From: Adrian Dowd
Sent: 26 August 2022 10:38
To: Planning
Cc: Ben Taylor
Subject: Application 3/2022/0589 - 1 Ribble Lane Chatburn

Application 3/2022/0589 1 Ribble Lane Chatburn

Boundary treatment plan

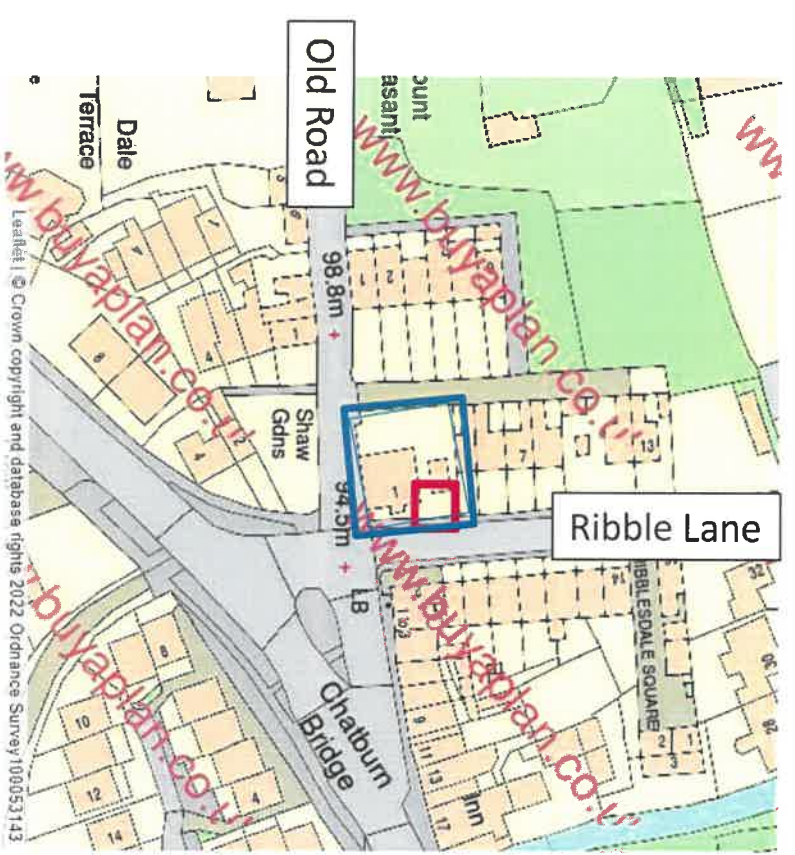
In my opinion, the linearity, integrity, materials and form of the boundary walling are an important element of the character and appearance of Chatburn Conservation Area. The loss of this section would be harmful to the character and appearance of Chatburn Conservation Area – see section 72 of the Act, NPPF (199, 200 and 202) and DME4 and DMG1. The harm to the conservation area (the designated heritage asset) is ‘less than substantial’ because it affects only part of the conservation area. NPPF paragraph 202 requires any public benefits (this includes contractor employment) to be considered in the ‘planning balance’.

Boundary walls: built from the abundant local carboniferous limestone, these are a distinctive feature of the conservation area. The stone is laid in large, roughly squared off blocks, and the walls are generally 1 to 1.5 metres high or up to 2 metres high where they surround walled gardens and larger houses. Around some properties (for example, the churchyard and school) they are topped by a triangular coping stones. Walls defining the boundaries of former farm buildings and running along the banks of the Chatburn Brook are identical to field walls, topped by tall and short stones, alternately set on edge and set flat. Appraisal page 19.
